PLANNING CONSULTATION RESPONSE

Application No	<u>2026/0592</u>
Proposal	Advertisement Consent for 2no. large flex-face box fascia signs and 1no. post sign.
Address	2A Athena Way, Hoyland Common, Barnsley, S74 0FQ
Date of Consultation Reply	24/08/26
Consultee	Highways Development Control

Fascia sign (flat panels / flex face))

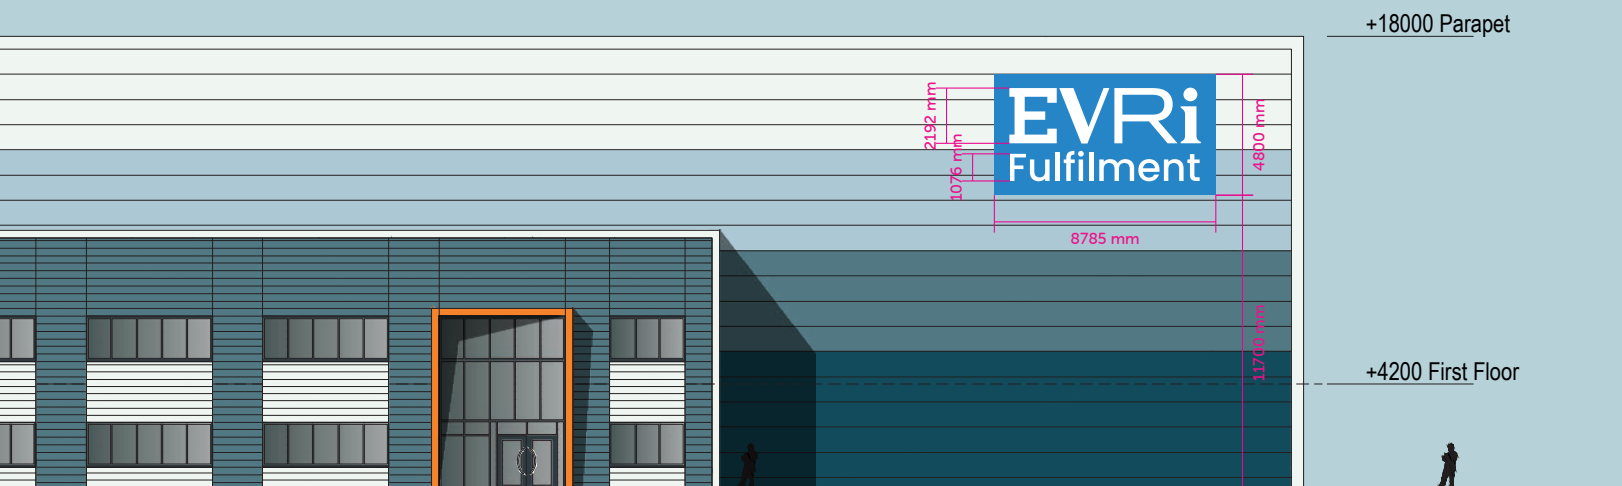
The proposed signage comprises a large logo fascia sign and a totem directional sign, which are to be contained within the grounds of the existing Evri distribution centre and is not considered likely to result in any adverse impact on the public highway or highway safety.

As such, it is not wished to raise any objections to the proposal from a highways point of view.
